**Consultation Response from KC,
Lead Local Flood Authority**

2024/91998 former, Almondbury High School, Fernside Avenue, Huddersfield, HD5 8PQ

Date Responded: 19/08/2024.

Appendix 7: Proposed Outline Levels and Proposed Drainage Layout

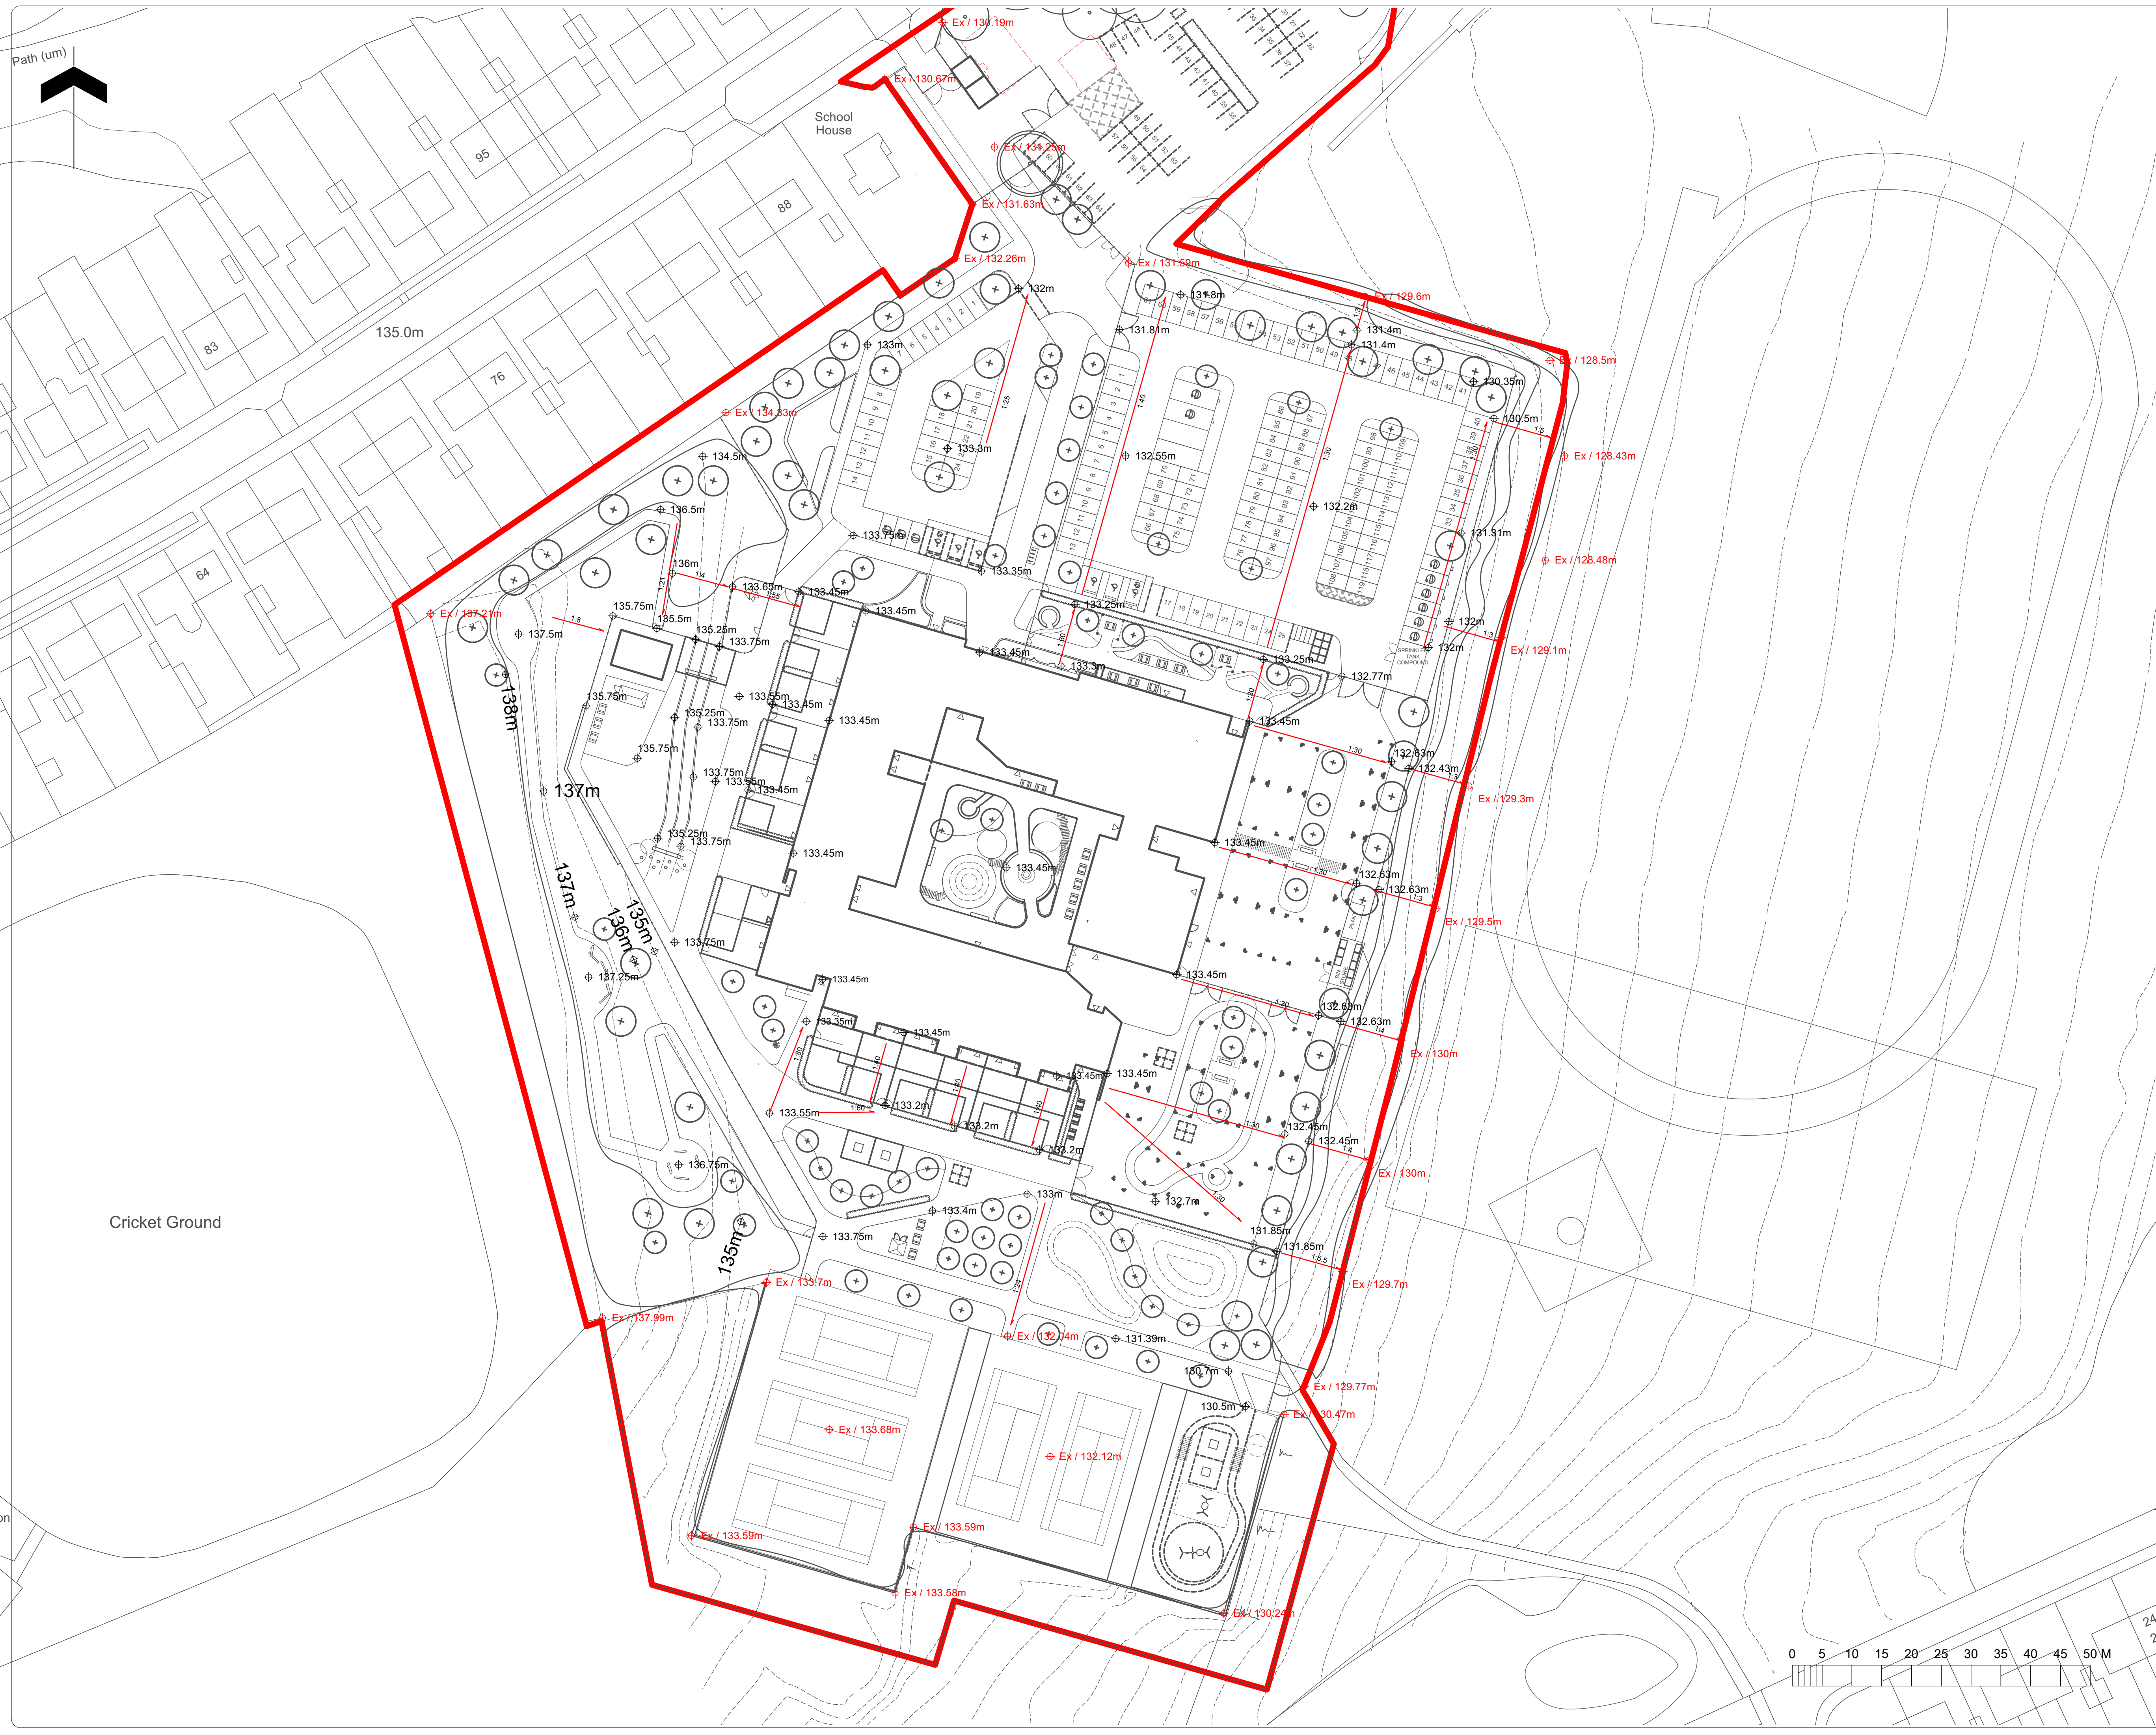
The LLFA accepts that infiltration to ground is not feasible and there is no suitable watercourse nearby, therefore the attenuated surface water should discharge to the Yorkshire Water sewer in Eastlands as indicated on the submitted Proposed Drainage Layout.

The LLFA notes the proposal to utilise a Tubersider type storage tank - however, please confirm the design life of the structure and any guarantees or BBA certification to ensure the tank will perform adequately for the duration of the development's life.

Further, it is noted that the proposed discharge rate stated in the Flood Risk Assessment & Drainage Strategy is 3.5 l/s whereas the drawing states a flow control device rated at 49.9 l/s is to be installed. Please revise either the FRA or the drawing so that they concur. However, note that the LLFA will accept the 49.9 l/s figure as it is based on 30% betterment of the existing surface water run-off rate. This discharge rate will need to be agreed with Yorkshire Water as the receiving sewer may not have sufficient capacity.

Development shall not commence until a detailed design scheme detailing foul, surface water and land drainage, including agreed discharge rate with the LLFA (**49.9 l/s**) indirectly or directly to watercourse, attenuation for the critical 1 in 100 (plus an allowance for climate change) rainfall event, attenuation construction details /design, plans and longitudinal sections, hydraulic calculations and phasing of drainage provision has been submitted to and approved in writing by the Local Planning Authority. The scheme shall include a risk assessment and method statement, in accordance with CDM Regulations 2015, for access to and into the attenuation structure, and the scheme shall include a maintenance and management plan for surface water infrastructure. No part of the development shall be occupied until such approved drainage scheme has been provided on the site to serve the development or each
